Please ask for: Ms Iqraa Malik
Email: iqraa.malik@terraquest.co.uk
Telephone: 0121 234 1390
Our Ref: FP/3/25/HH
Your Ref:
Date: 15th January 2025

Application for Planning Permission for Works or Extension to a Dwelling

Development: Proposed timber shed and front garden fence
Location: 7 Second Avenue Felpham PO22 7LJ

Site Plan As Proposed
Scale 1 : 100

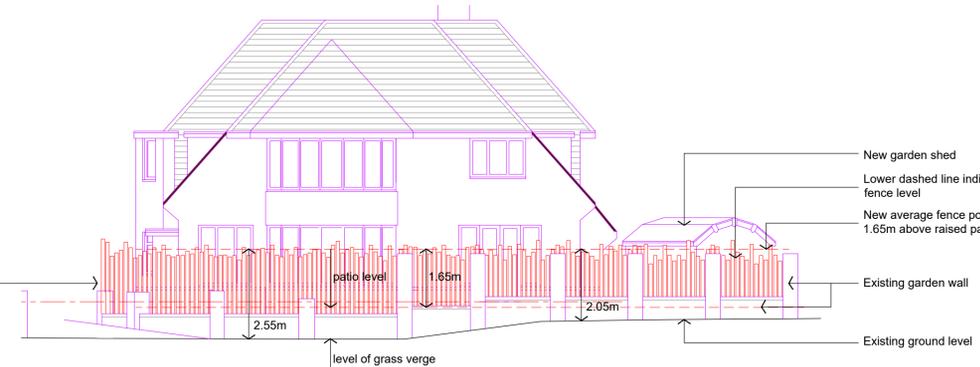
Block Plan

You are required to have dimensions from the proposed extension(s) to all site boundaries. Please amend.

Elevation Facing Road 1 : 100

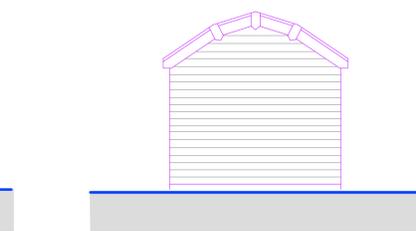
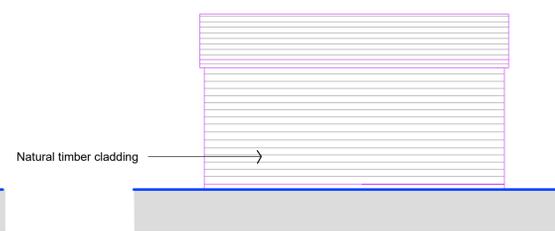
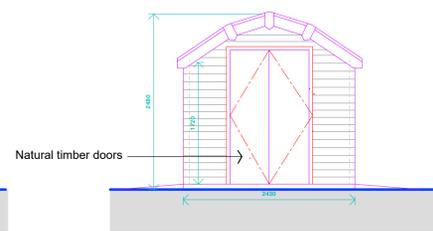
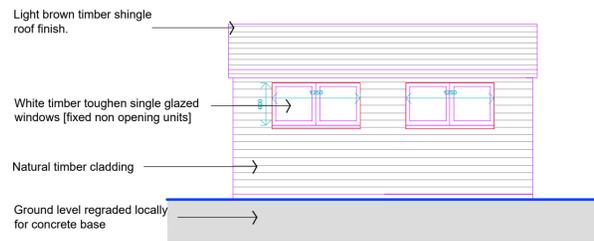
Elevations

Please submit electronic plans in pdf format clearly labelled proposed fence elevations at a scale of 1:50 or 1:100. Further details can be found in the Validation Requirements List.
